I-25 / Palmer Ridge Road
El Paso County

May 29, 2025

RE: Monument Ridge East Filing No. 1 (SF2514)
Monument Ridge Metropolitan District Nos. 1-3 (ID245)

FILE LOCATION: S:\35 1669.002 MONUMENT RIDGE EAST\500 CADD\504 PLAN SET\SITE DEVELOPMENT PLANS\SP01.DWG

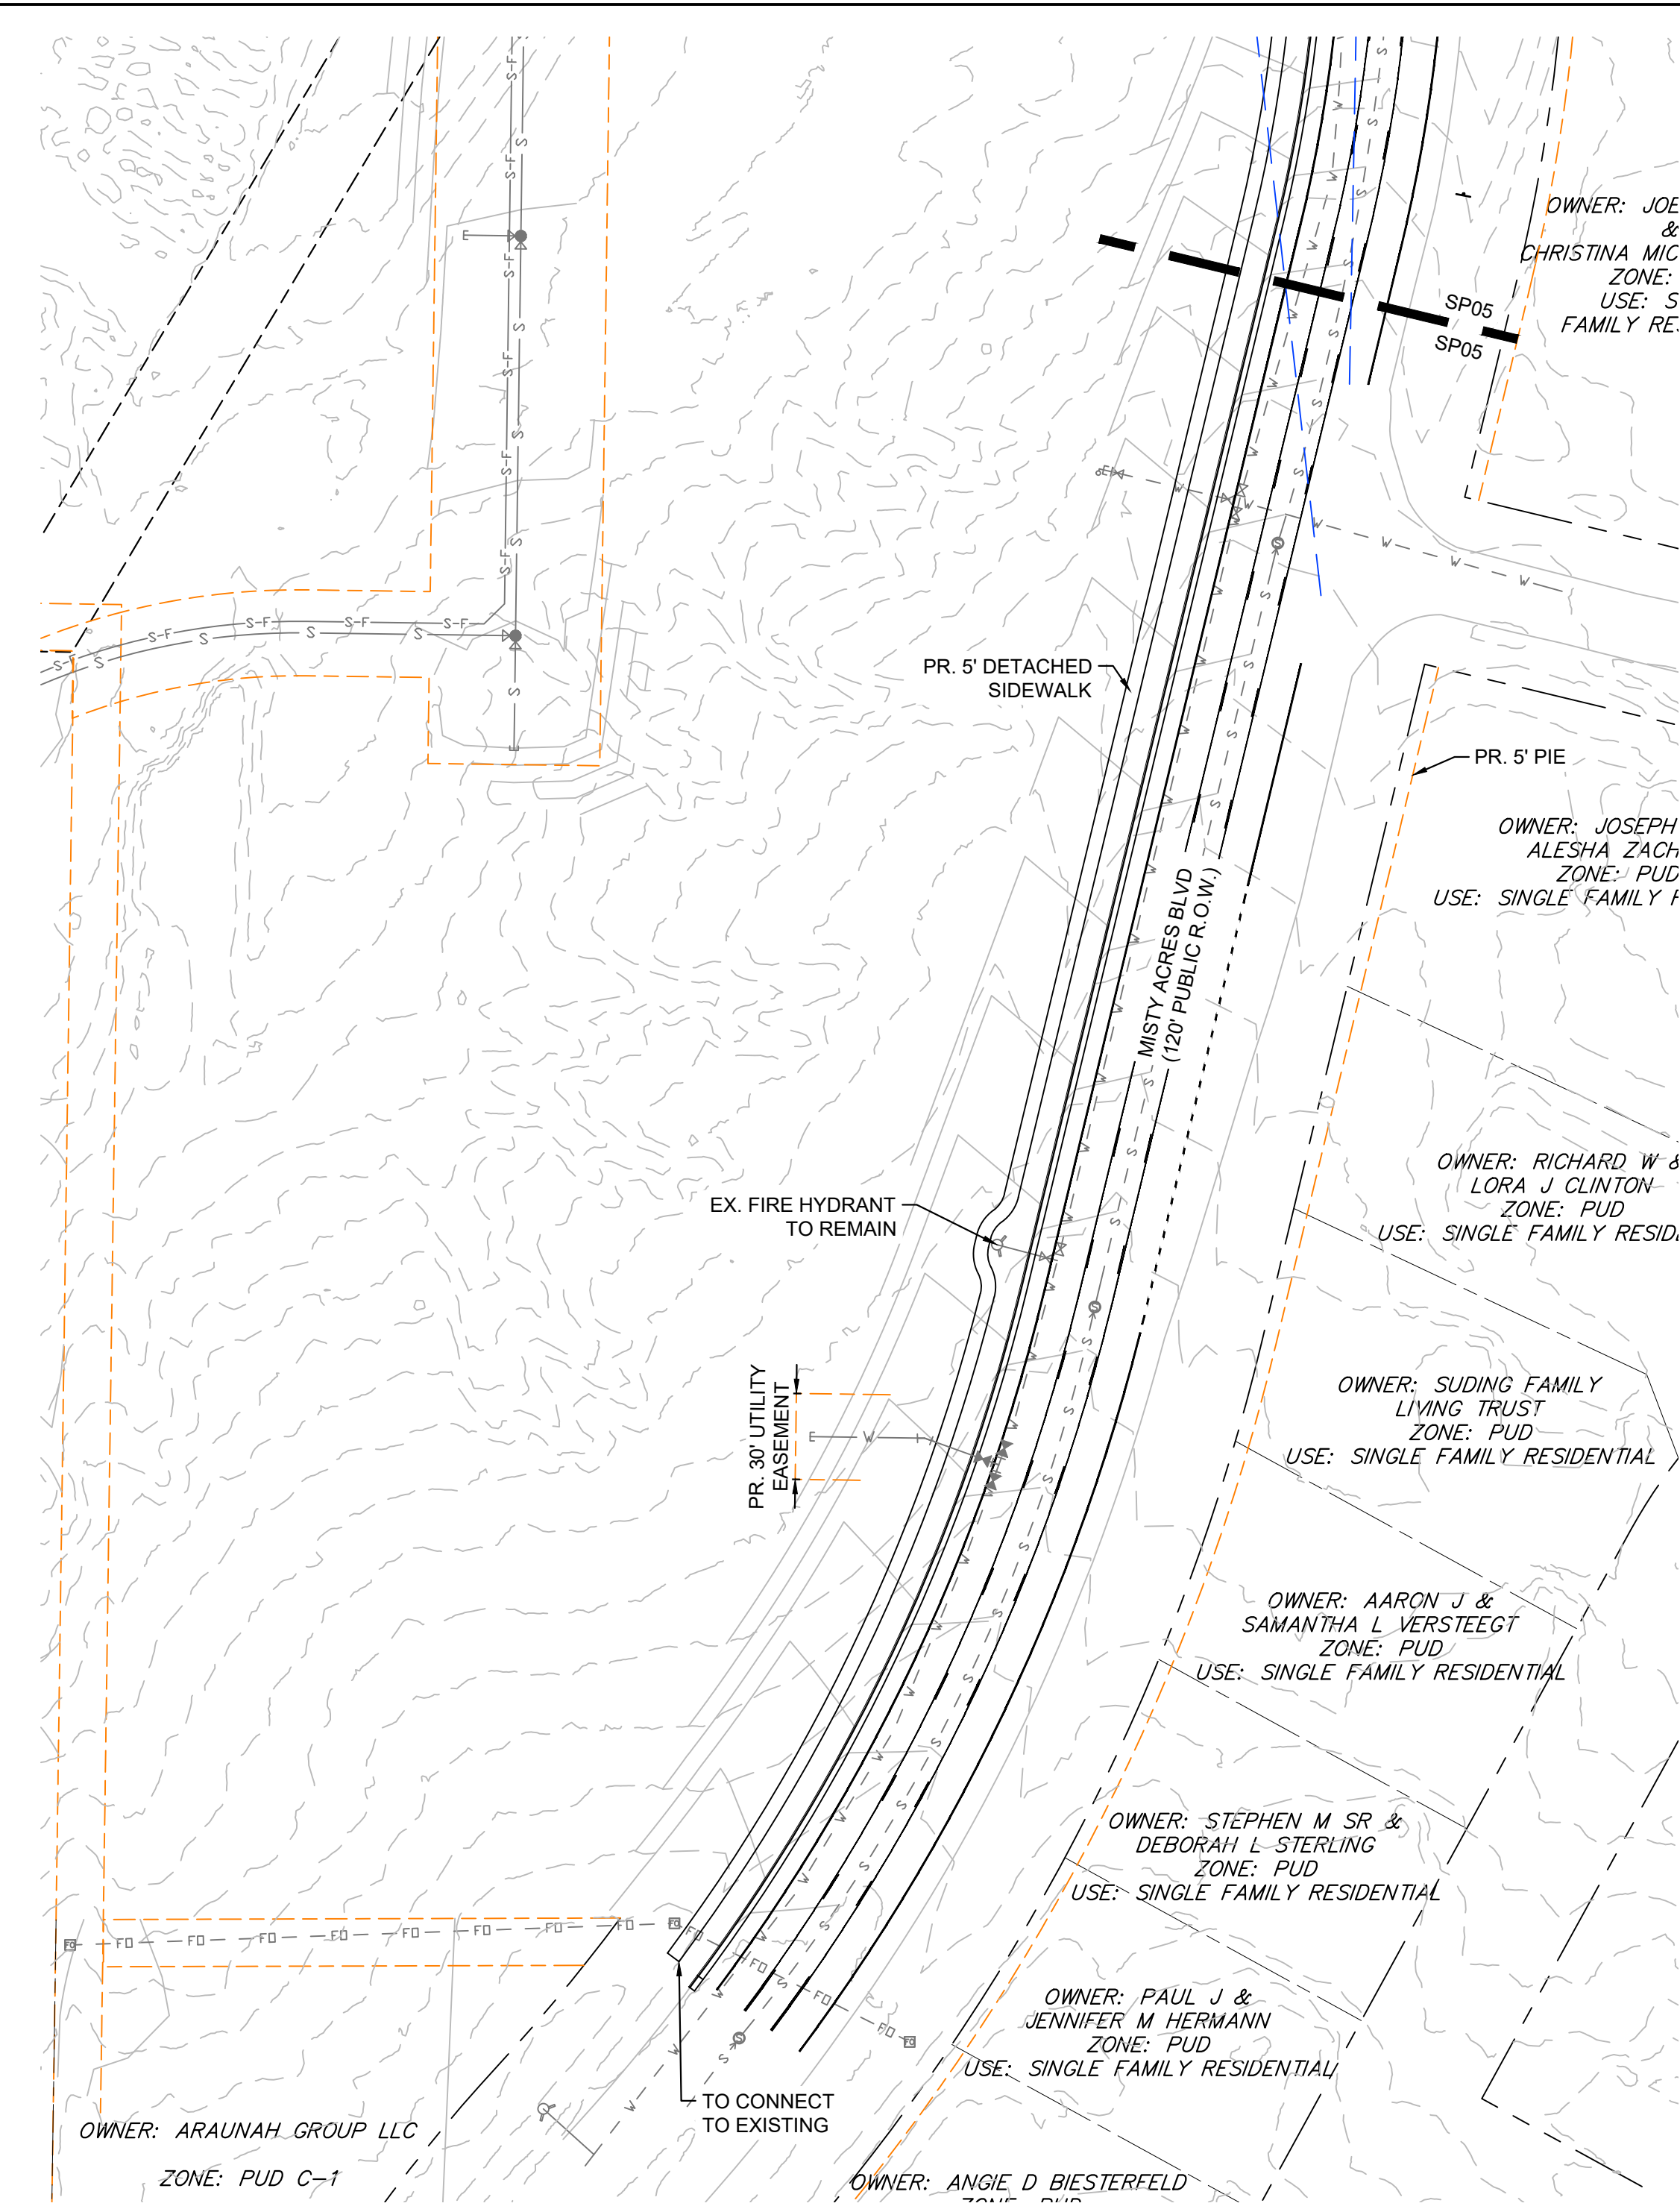
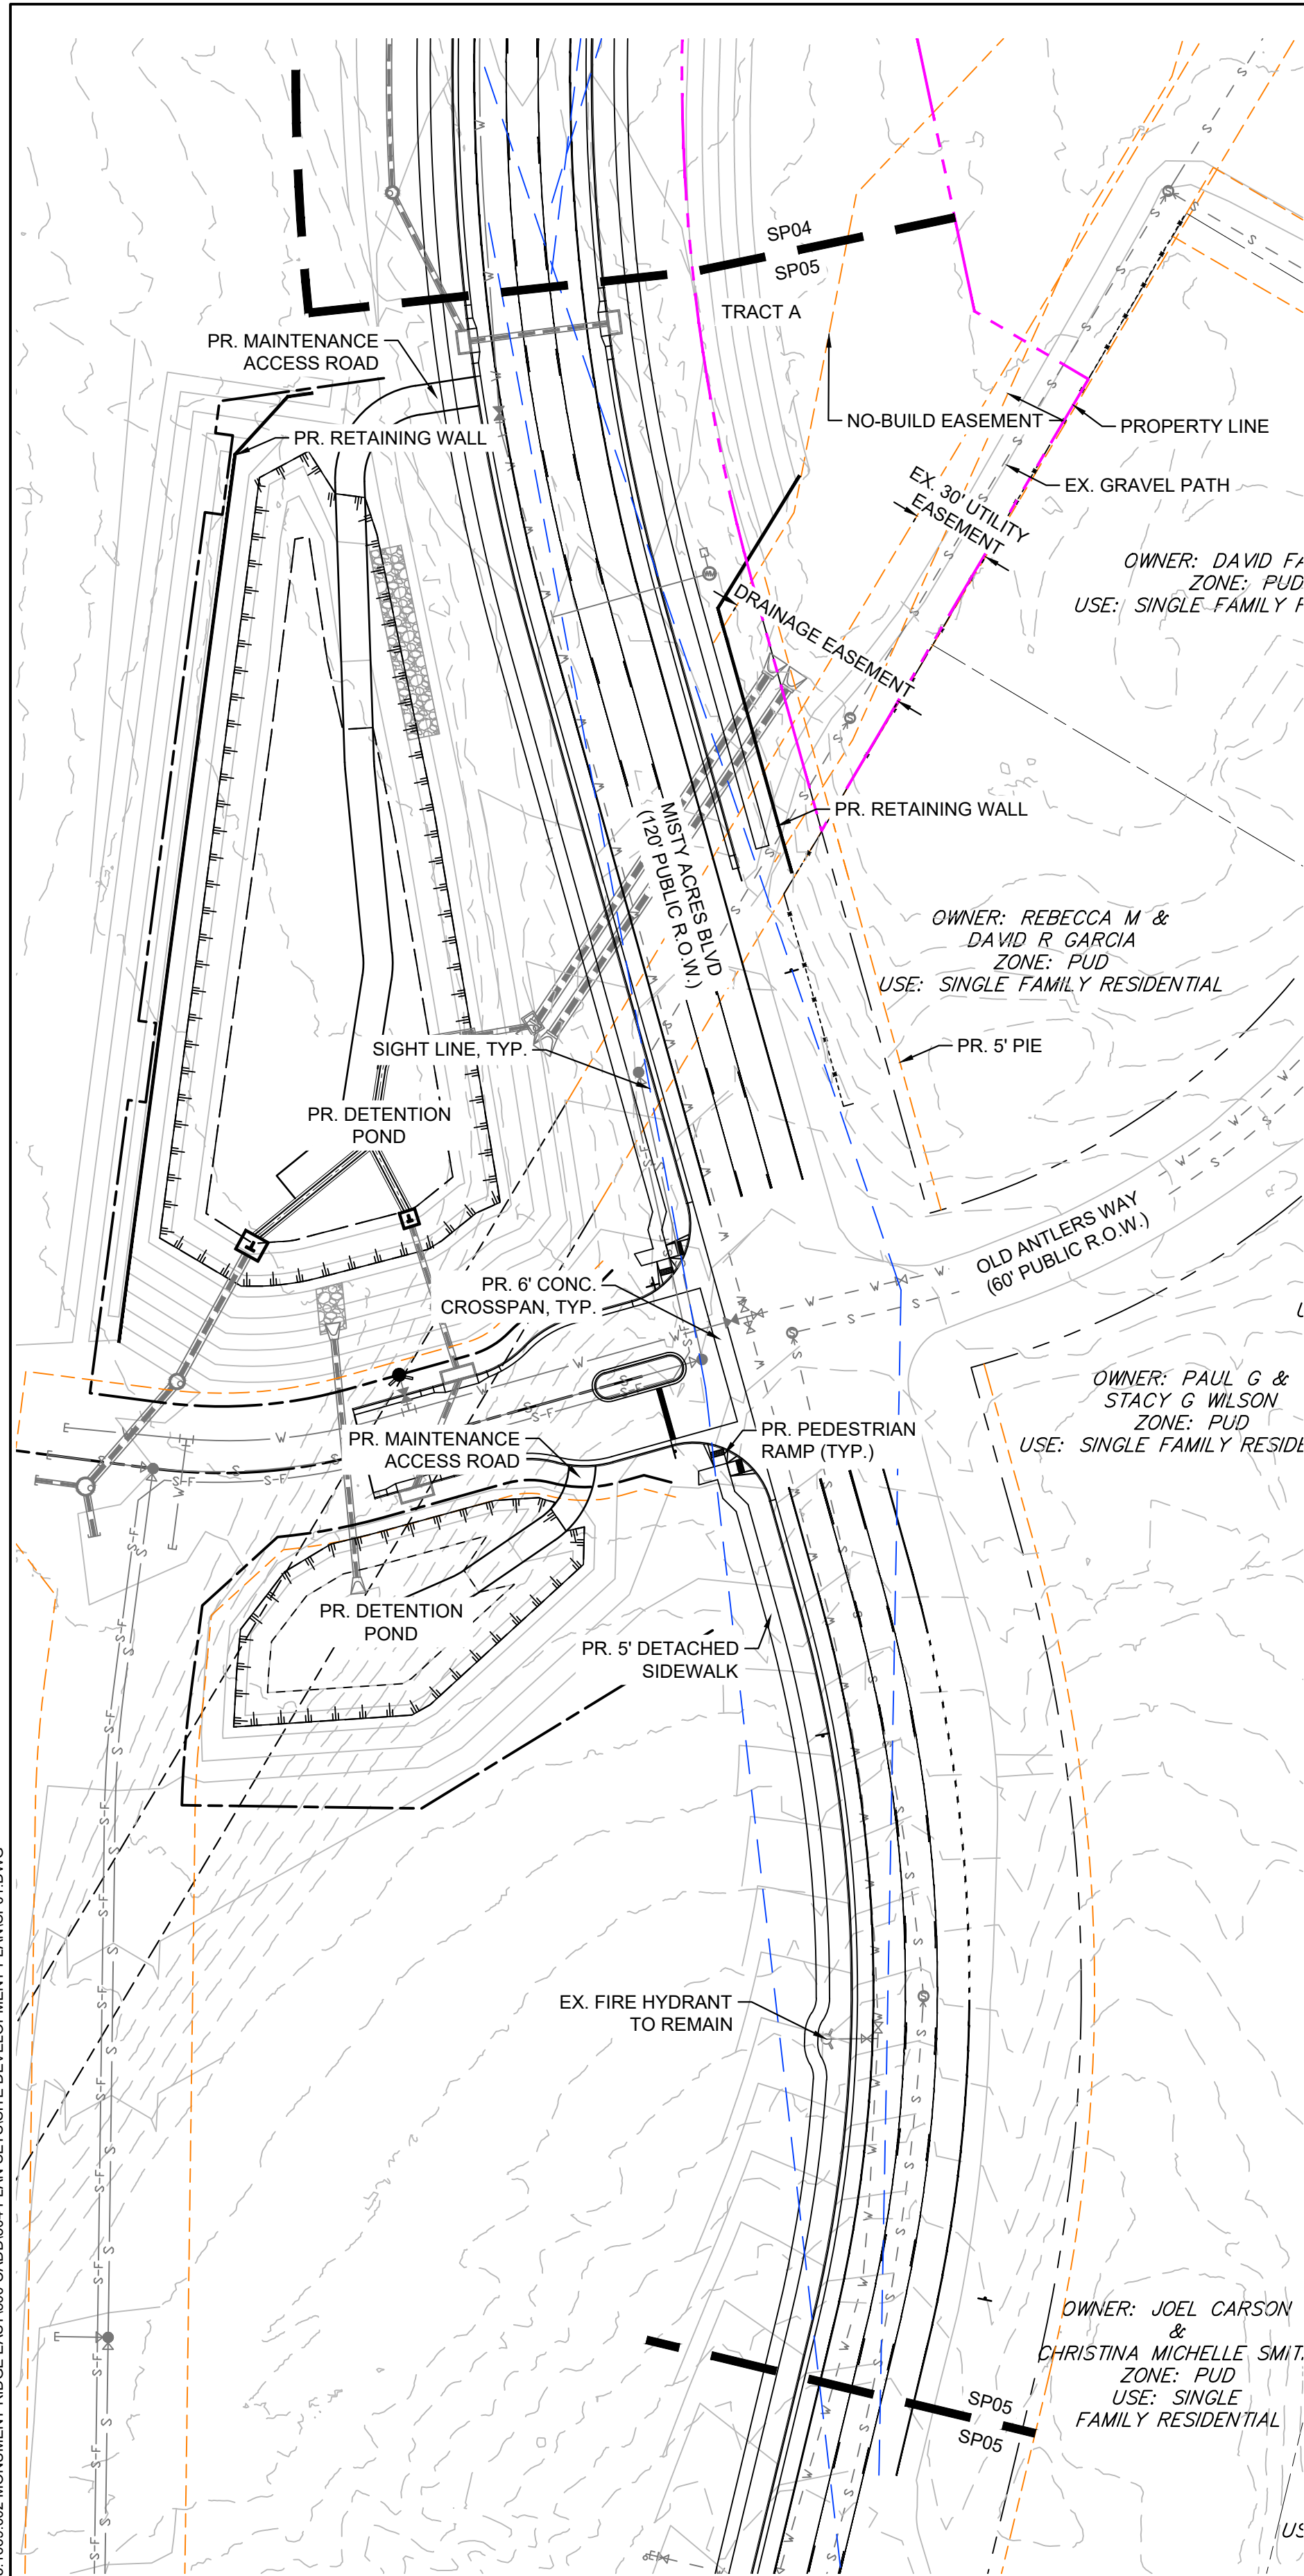
- The Development Plans have a new access from the I-25 Frontage Road. This access is north of the existing deer guard (labeled as a "Cattle Guard" in the plans). If the access (labeled as "Catch slope") is to be constructed, the new driveway will require a new deer guard (similar to the deer guard present) to prevent animals from entering the I-25 corridor. A new deer guard would need to be adequately sized in accordance to the new driveway width. Also, the current placement of the deer guard was solely placed to access this property.

- The Development's connection to East Palmer Divide Ave (not the frontage road) appears to be directly on the existing Deer Guard. This is not shown in the plans. The double CMP are shown, but not the deer guard. The deer guard shall remain in place. A new deer gaurd is suggested since the driveway will create a new access point for deer and elk to enter the highway corridor. This Deer Guard is owned by El Paso County.

- There are no details of how the new proposed access points will connect to the existing wildlife fence.
- Cannot see details or how the new driveway on the north end of the property will accomodate the Monument Hill Road Frontage Road. Looks to be a traffice conflict with driveways being very close.
